Our Case Number: ACP-323849-25

Re: The proposed development is for a mixed use development that seeks the regeneration and adaptive reuse of a strategic brownfield site, as part of the Limerick City and County Council 'World Class Waterfront revitalisation and transformation project' 'Cleeves Riverside Quarter' in the townland of Farranshone More in Limerick City.

Re: Proposed Development - Cleeves Riverside Quarter / Riverside Campus

Observation / Objection

1 Stonetown Terrace Plant Level Plan
1 : 200
Note: Refer to roof plan and lower levels for dimensions.

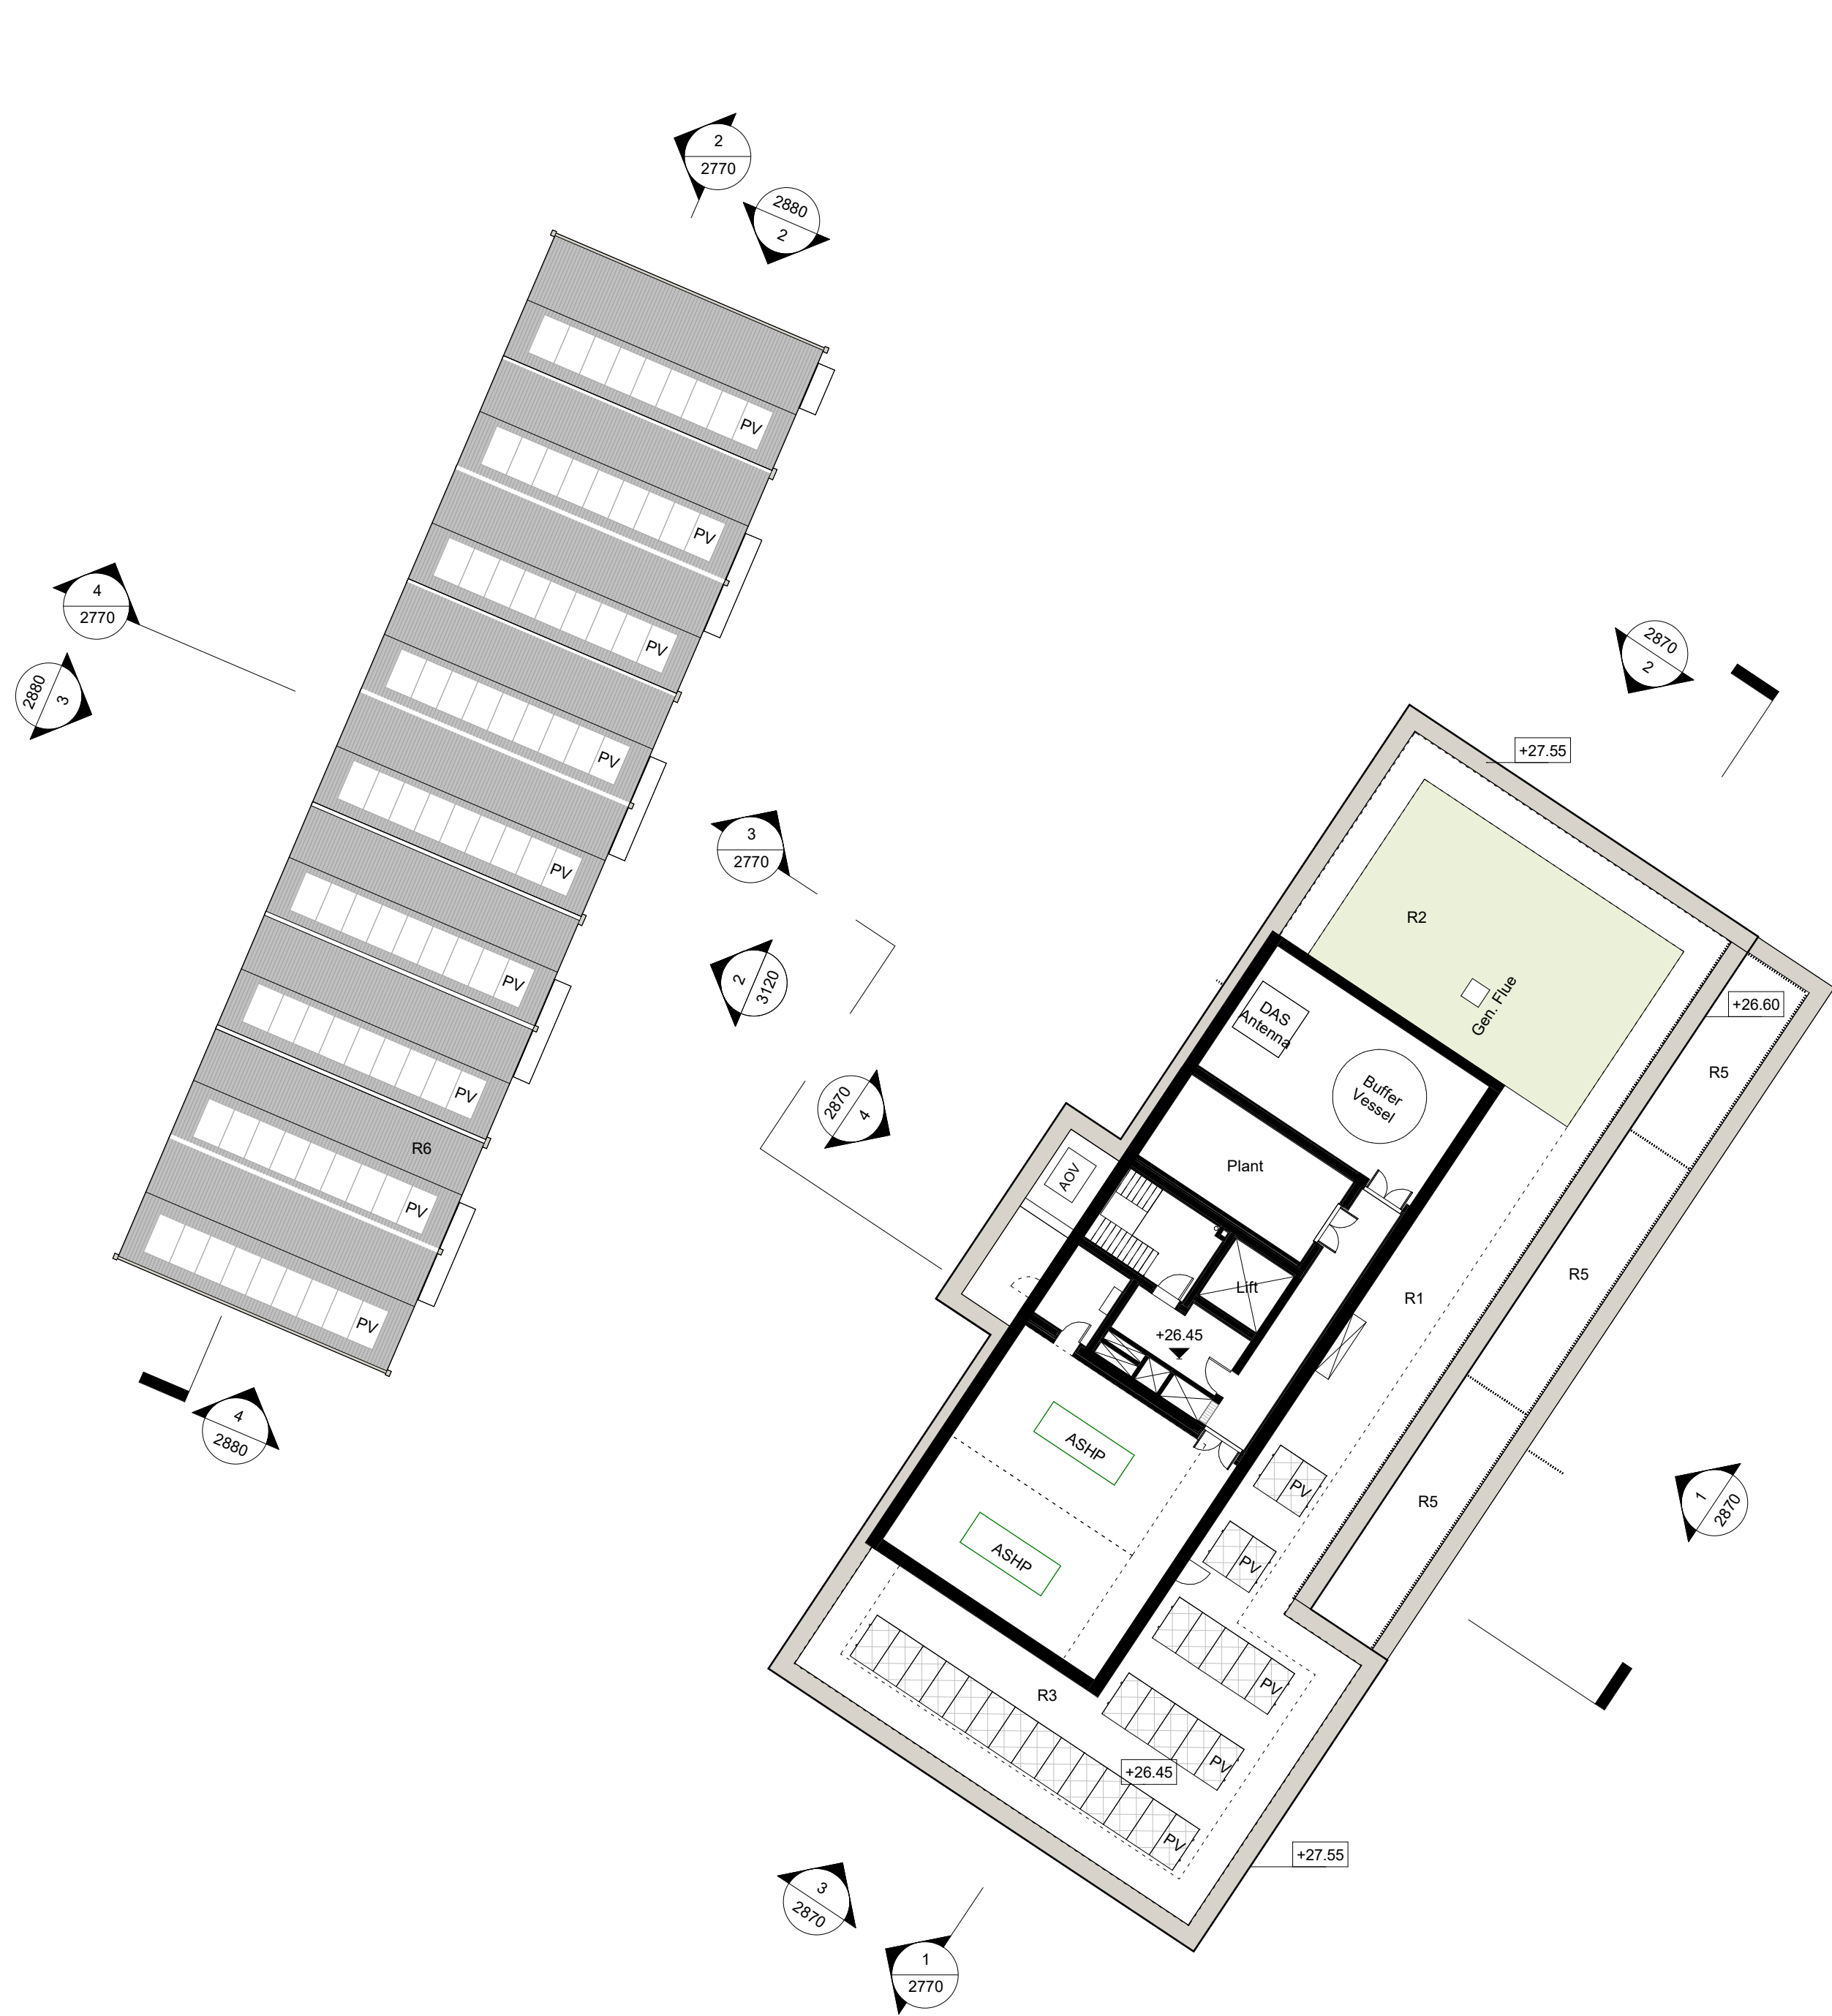
- The possible severe negative impact of noise pollution generated by the operation and maintenance systems, pumps, generators, fans, compressors etc, of the planned roof-level plant and building services.

- **There is scant detail provided regarding the operational impacts, the noise levels, visual impacts, hours of operation, maintenance, sound screening etc.** This seemingly insufficient/ inadequate planning of such an important factor re the building, undermines any trust that the work will be executed properly and according to the highest standards.
